Subdivision Comments

RE: LPF-23-00002 Tumbling Ridge Plat

TUMBLING RIDGE PRELIMINARY PLAT

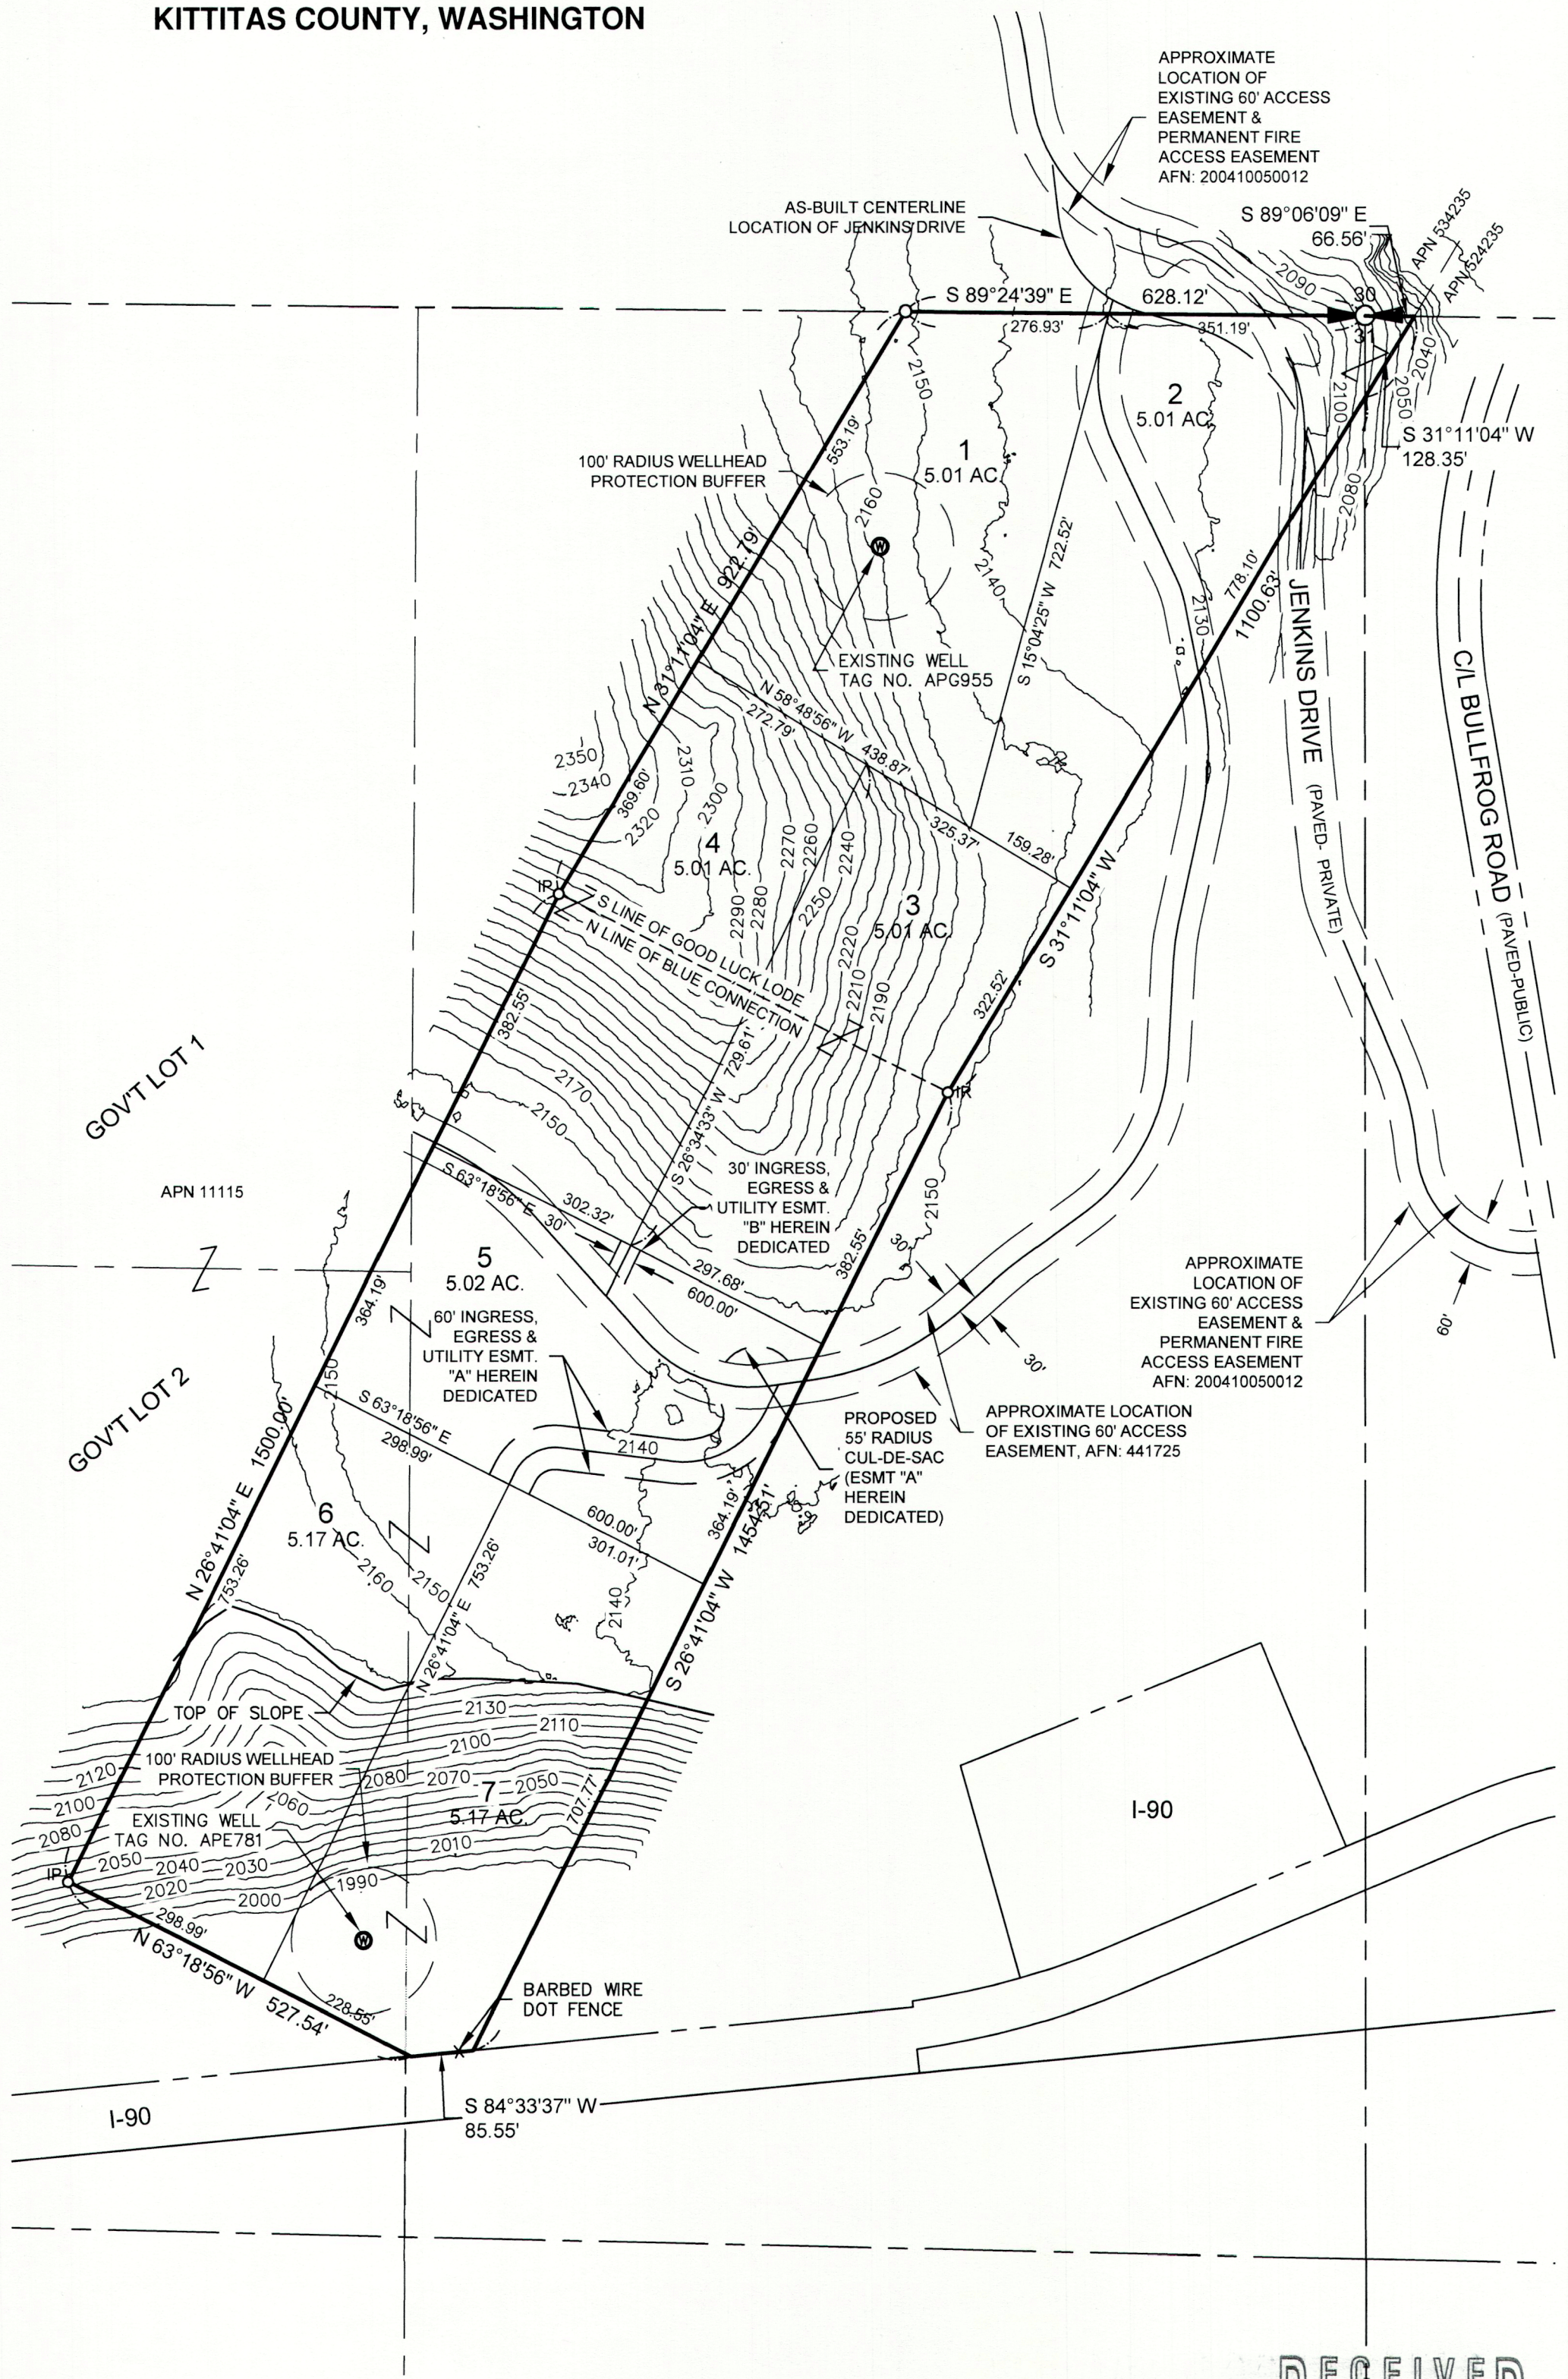
The proposed Group B water system must have a well drilled and a Group B water system approved to be able to serve 7 connections with a public water system ID# issued prior to obtaining final plat signature.

A Group B water system must be approved with a state identification number issued prior to obtaining final plat signature.
